EL PASO COUNTY GRADING AND EROSION CONTROL PLAN CHECKLIST

SHEET
UP1
04

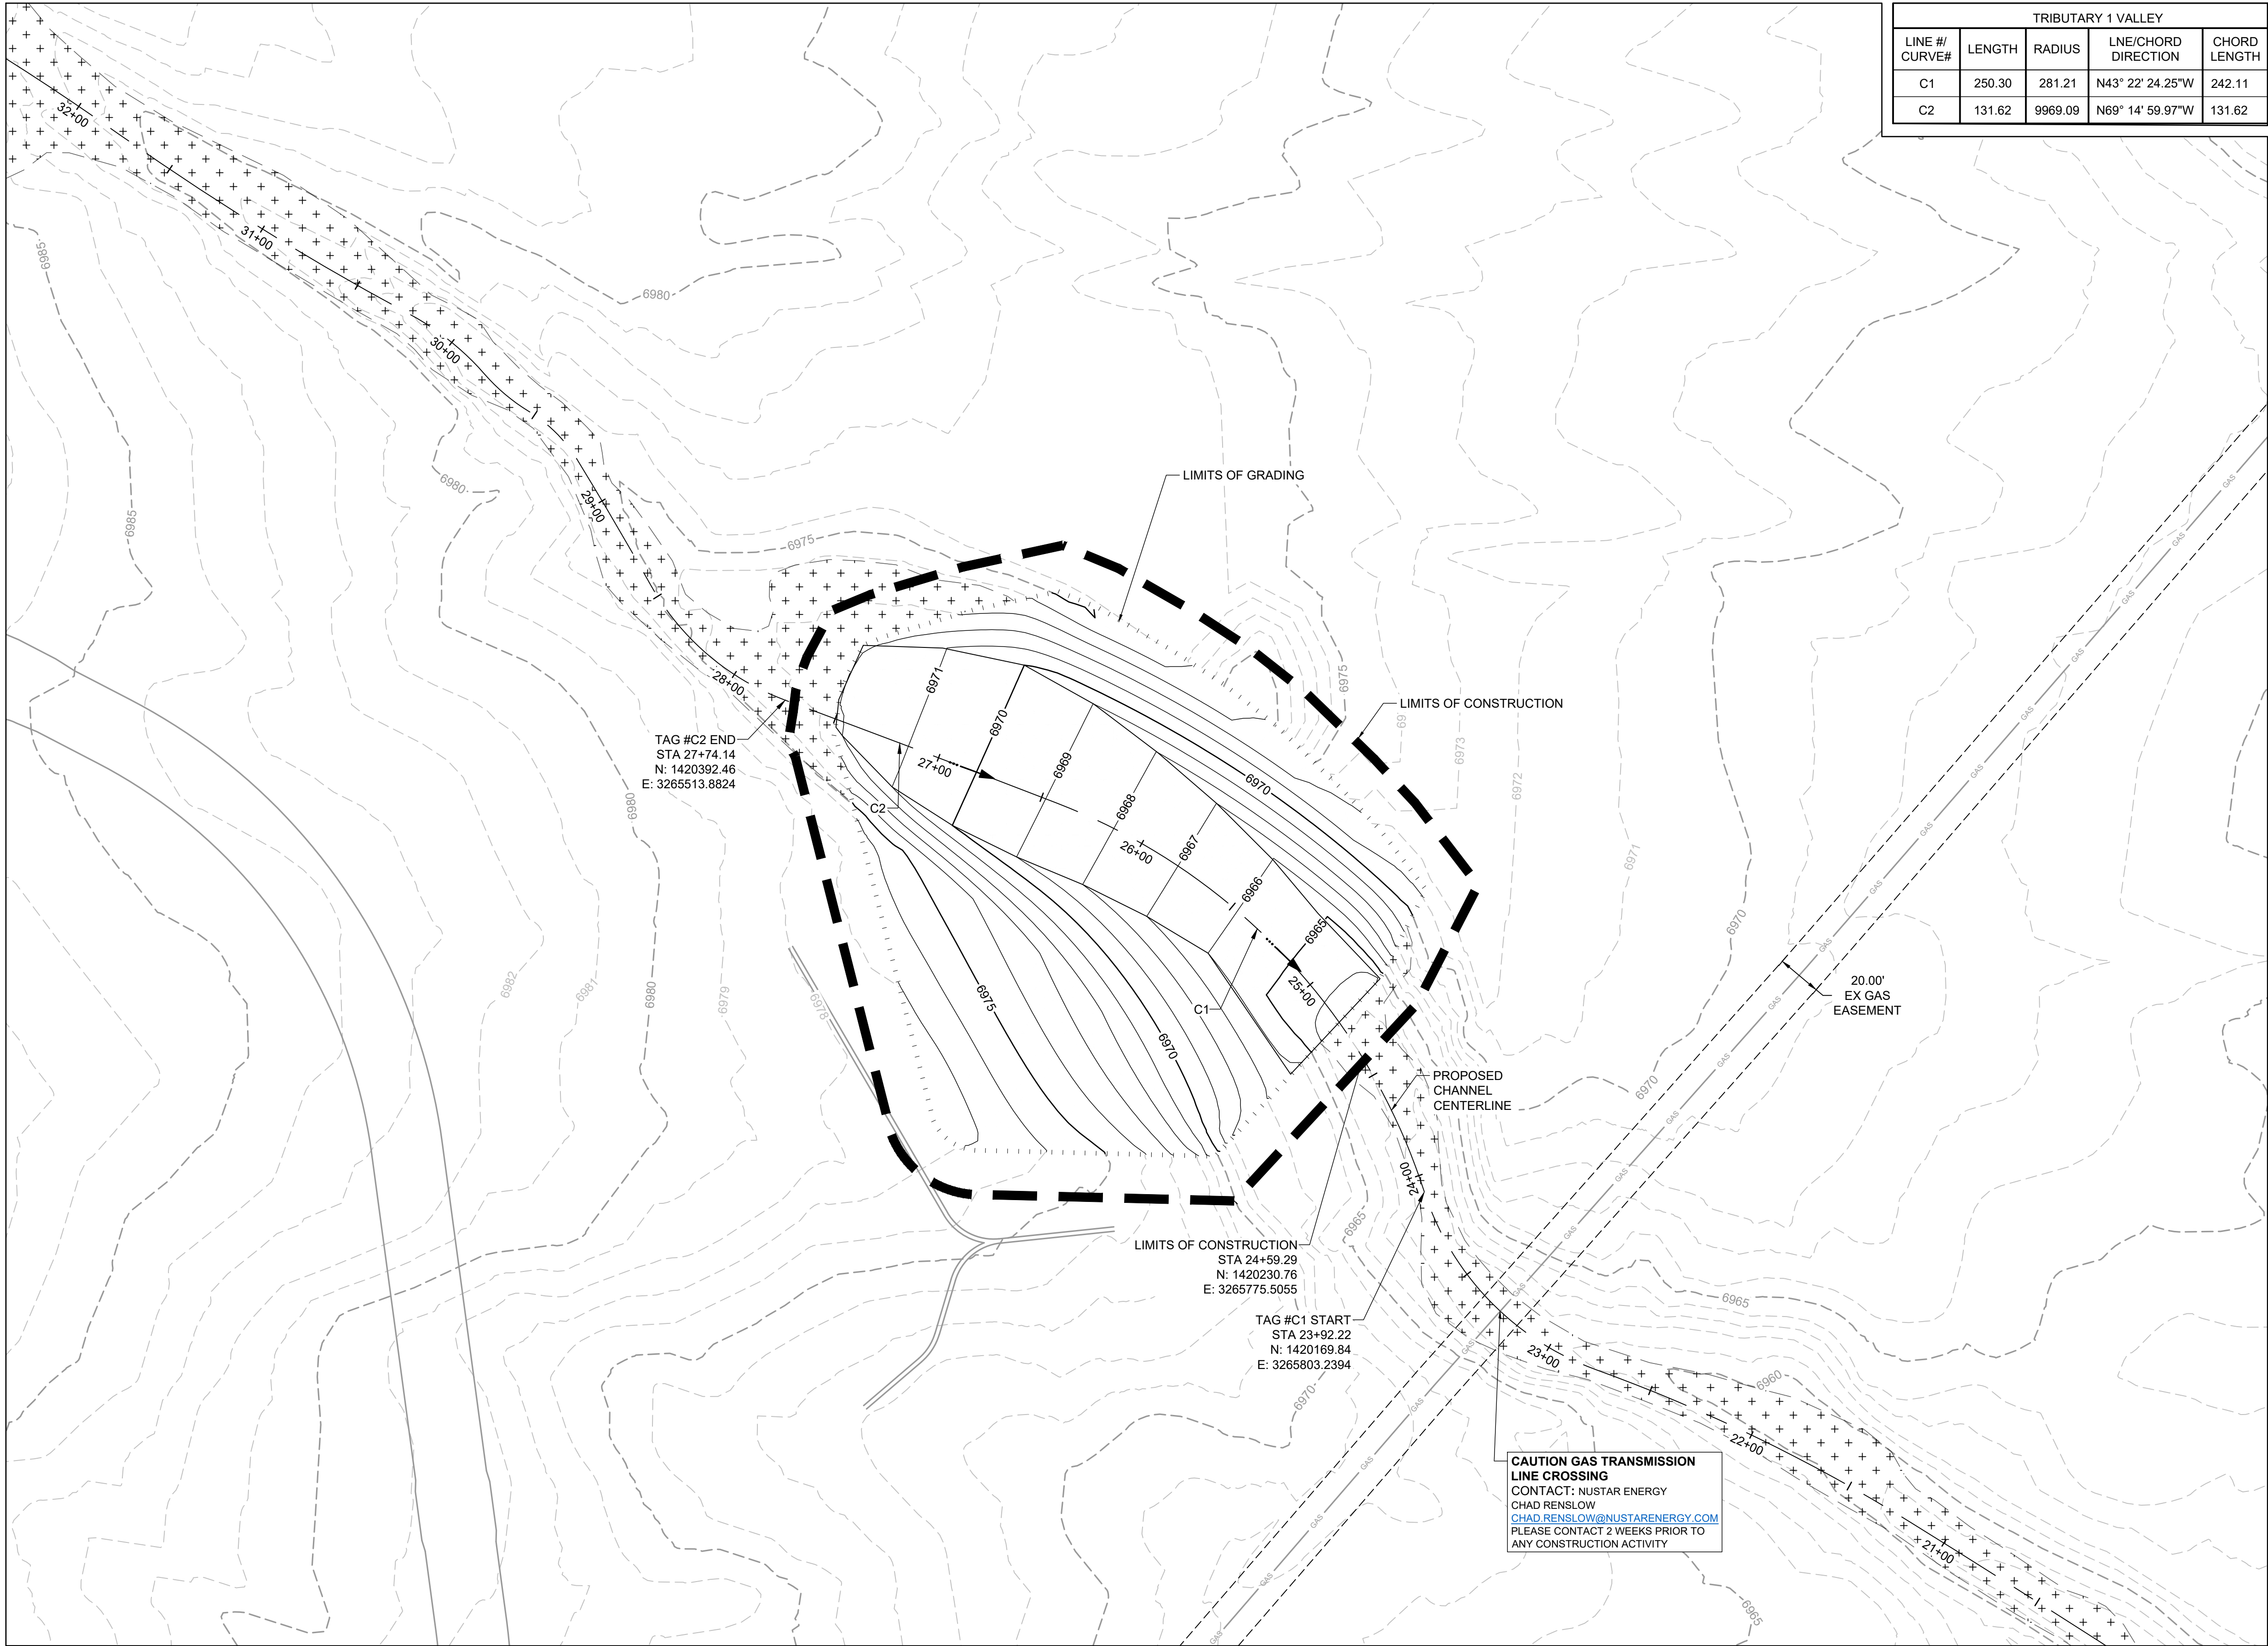
PL's will be more clear once the adjacent subdivisions are labeled.

Applicant	EPC
1. GRADING AND EROSION CONTROL PLAN			
a	Vicinity map		Y
b	Adjacent city/town/jurisdictional boundaries, subdivision names, and property parcel numbers labeled		N
c	North arrow and acceptable scale (1"=20' to 1"=100')		Y
d	Legend for all symbols used in the plan		Y
e	Existing and proposed property lines. Proposed subdivision boundary for subdivision projects		N
f	All existing structures		N/A
g	All existing utilities		Y
h	Construction site boundaries		Y
i	Existing vegetation (notes are acceptable in cases where there is no notable vegetation, only grasses/weeds, or site has already been stripped)		Y
j	FEMA 100-yr floodplain		Y
k	Existing and proposed water courses including springs, streams, wetlands, detention ponds, stormwater quality structures, roadside ditches, irrigation ditches and other water surfaces. Show maintenance of pre-existing vegetation within 50 feet of a receiving water		Y
